memorandum

subject Review of 5637 Mercer Way – January 24, 2019 MI Treehouse Reasonable Use Exception Application (CAO 15-001 and SEPA15-001) Responses

Environmental Science Associates (ESA) has prepared this memorandum on behalf of the City of Mercer Island (City). The purpose of this memo is to review applicant-submitted materials and responses to ESA’s previous review memo and to confirm whether the proposed project complies with Mercer Island City Code (MICC) Chapter 19.07 – *Environment*. The site is located at 5637 Mercer Way (Parcel 1924050312).

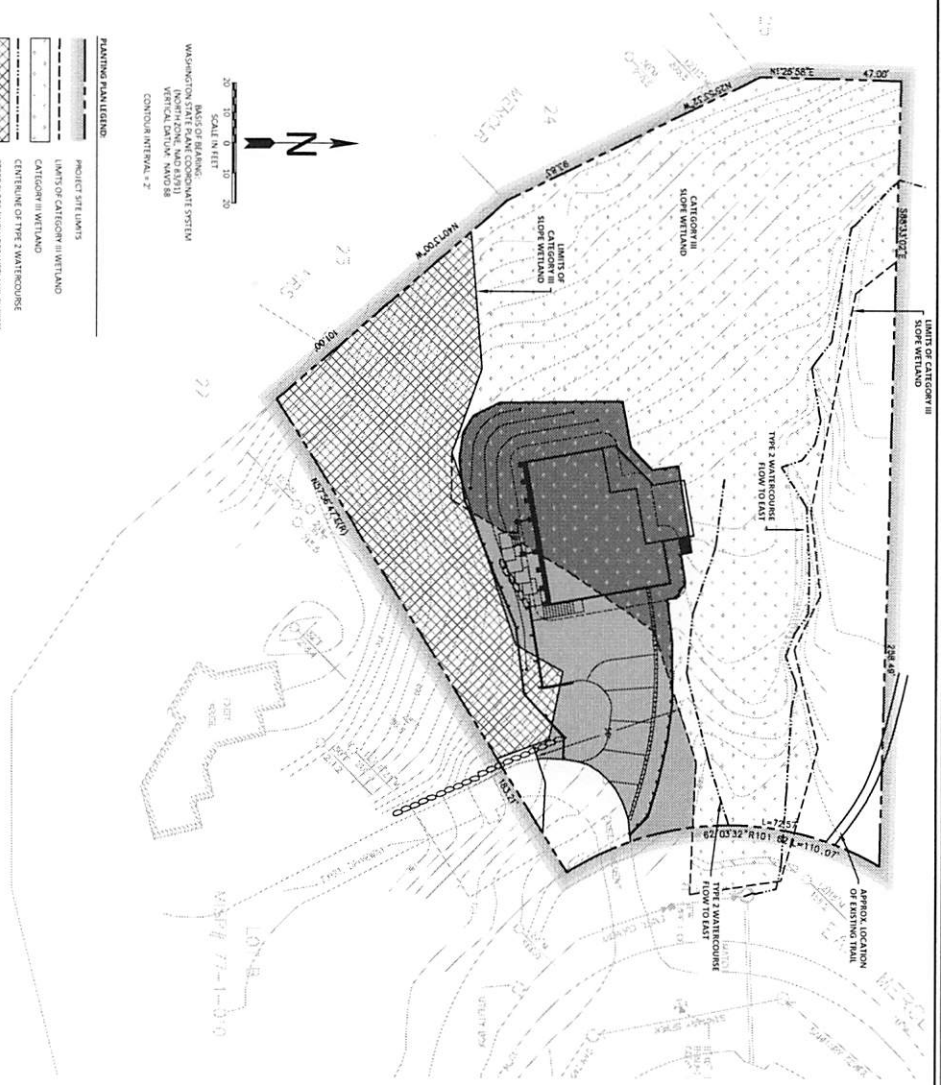
15. Mitigate onsite to compensate for permanent buffer impacts.
 - *Sewall provided an updated planting plan, dated January 24, 2019, that depicts planting locations, schedule, and quantities.*
